**From:** Gruber, John [GruberJ@wsdot.wa.gov]  
**Sent:** Thursday, July 03, 2008 2:50 PM  
**To:** Mackenzie Moynihan  
**Cc:** Holmstrom, Rick; Harris, Jason; Gruber, John  
**Subject:** B. Gordon Short Plat - Access

TO: Mackenzie Moynihan, Staff Planner, Community Development Services  
FROM: Christina Wollman, Planner II *cw*  
DATE: June 19, 2008  
SUBJECT: B. Gordon Short Plat

SP-07-122

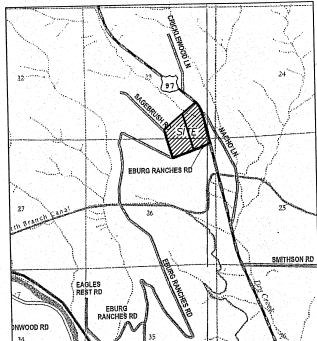
1. US 97: The plat incorrectly refers to US 97 as SR 97 and State Route 131. These references shall be corrected on the final plat.
2. Access via US 97: Ellensburg Ranches Road, the access for the proposed lots, originates from an existing approach off US 97. The Washington State Department of Transportation has jurisdiction over US 97. The applicant shall contact Dan Eberle with the WSDOT at (509) 577-1637 to see if any further conditions are applicable. A WSDOT access permit shall be required prior to receiving final approval.

3. Ellensburg Ranches Road Private Road Improvements: Ellensburg Ranches Road shall be improved to the Low-Density Private Road standard (per current Kittitas County Road Standards).

- a. Access easements shall be a minimum of 60'. The roadway width shall be 20', with 1' shoulders = 22' total width. These improvements shall be required from the intersection of U.S. 97, west, to the intersection of access easement “Q” or furthest point of access for any of the lots within this short plat.

5. Sagebrush Road Improvements: If Sagebrush Road is used as the access to Lot 5A-2, the road shall be improved to meet the same conditions as Ellensburg Ranches Road.

6. Easement 'Q': Easement 'Q' as it is currently proposed may serve no more than two lots. If access to more than two lots is proposed for Easement 'Q', the easement will need to be 60', the road improved to meet the same conditions as Ellensburg Ranches Road, and a cul-de-sac constructed at the end of the road.

7. Turnaround: Ellensburg Ranches Road and Sagebrush Road, if used, require a turnaround. A hammerhead turnaround may be constructed in lieu of a cul-de-sac. Additional easement may be required. Turnaround locations shall be shown on the plat. Hammerheads must be constructed as specified in the 2006 International Fire Code. Cul-de-sac requirements are shown below.
